From: Simon Davis
Sent: 12 October 2017 16:56
To: Planning Scanning
Subject: FW: 27 North Bersted Street - Southern Water Response BE/106/17/DOC
Attachments: Fwd 27 North Bersted Street.htm

Subject: D1304: 27 North Bersted Street - Southern Water Response

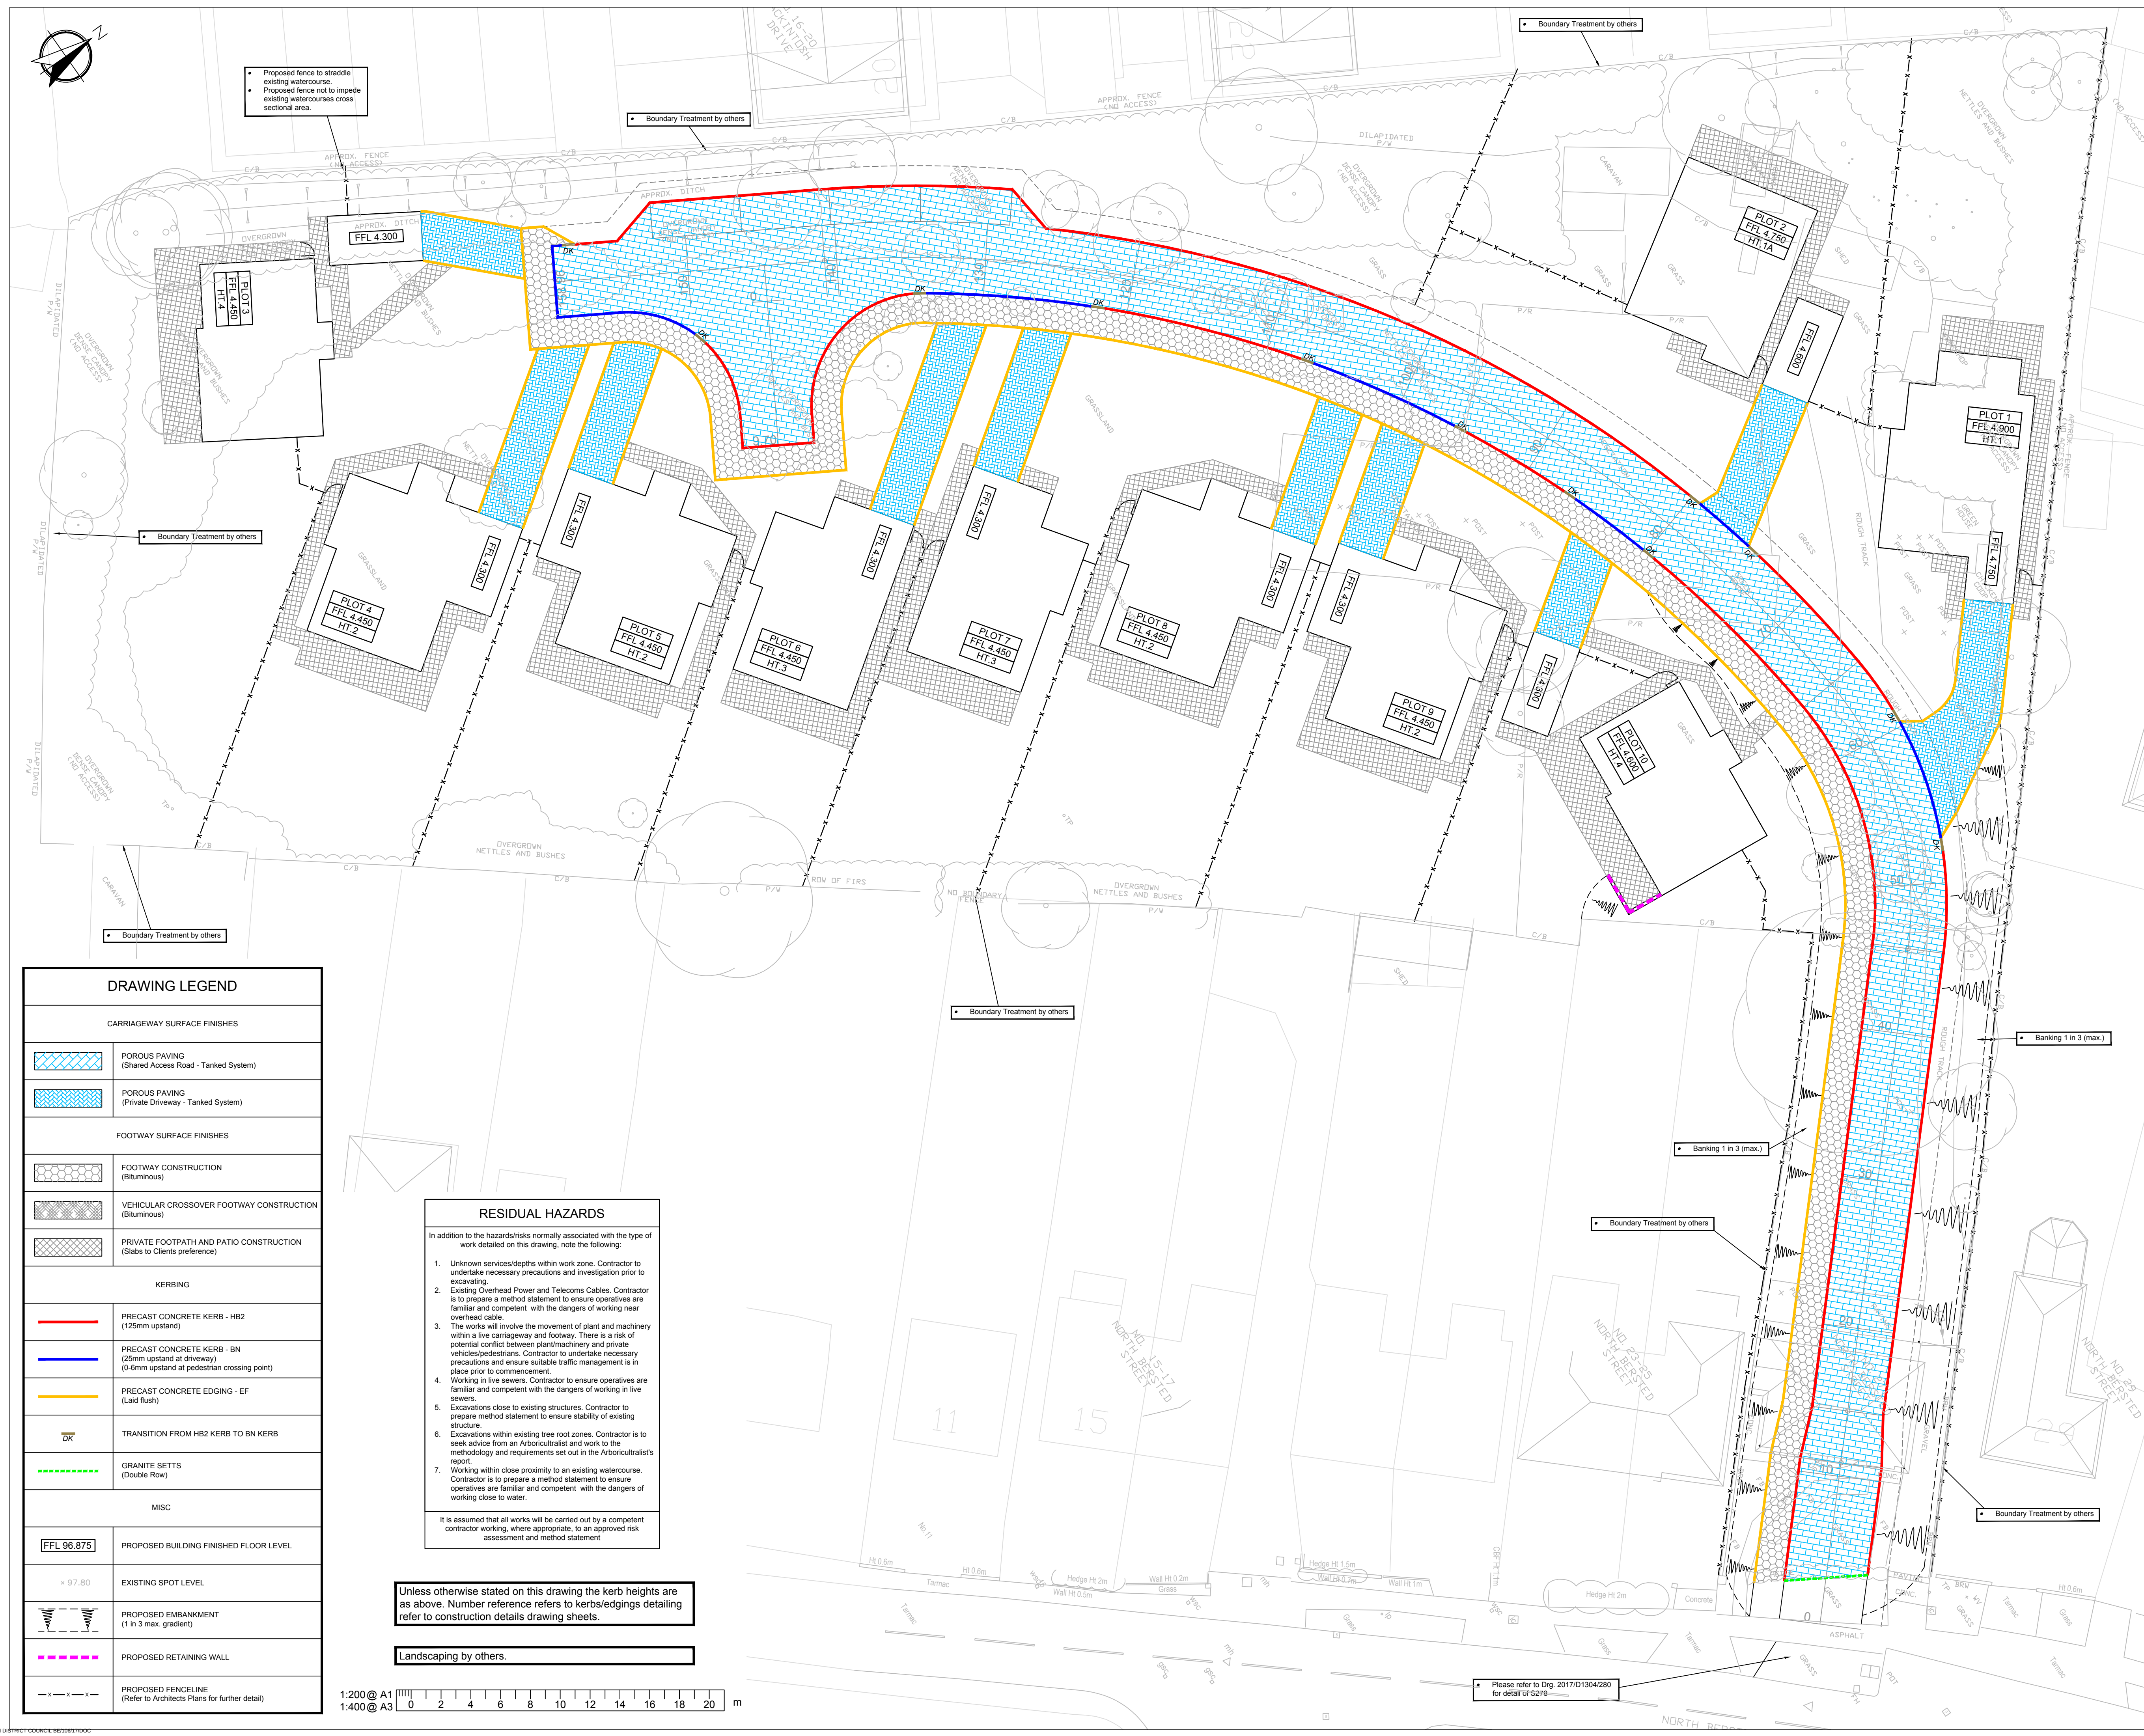
1. The Southern Water letter initial comment relating to condition 9 does not make sense or is incorrect. Please request clarification of what they actually mean.

2. There is no statutory requirement for the design of the proposed foul water drain system to meet the requirements of Sewer for Adoption, but in any case refer to points 3 & 4 below.

3. We note that Southern Water are referencing 'Southern Water requirements' however SFA7 para A6 states '*there are now no longer any company addenda for gravity sewers*'.

4. The design of the proposed foul drain system is in accordance with Sewers Adoption 7th Edition (latest version). This document states '*This guide is for use by Developers undertaking new development when planning, designing and constructing foul and surface water gravity sewers, lateral drains and pumping station, and rising mains intended for adoption under an Agreement made in accordance with Section 104 of the Water Industry Act 1991 (as amended)*'. It is **not** intended to offer the proposed foul water drainage system for adoption.

5. Although the design meets the requirement of SFA7, this document also states '*The guidance in Sewer for Adoption does not necessarily preclude alternative approaches. Any departures from the recommendation should be discussed with the undertaker as early as possible*'. The design of the proposed foul water drainage also meets the (statutory) requirements of Building Regulations approved document H which is clearly an acceptable alternative approach.

6. SFA7 does not place any restrictions on the proximity of sealed tanks or other drainage storage structures to foul sewers.
7. Consent has been obtained from WSCC, as Highway Authority for the 'private' Surface Water connection to the highway drain. (Attached)
8. The drainage strategy follows what was submitted and agreed for planning stage, Southern Water would have been a consultee at that stage.

The restrictions that Southern Water appear to be suggesting conflict with what NPPF and Arun DC drainage team seek to achieve (maximise the implementation of SuDS).
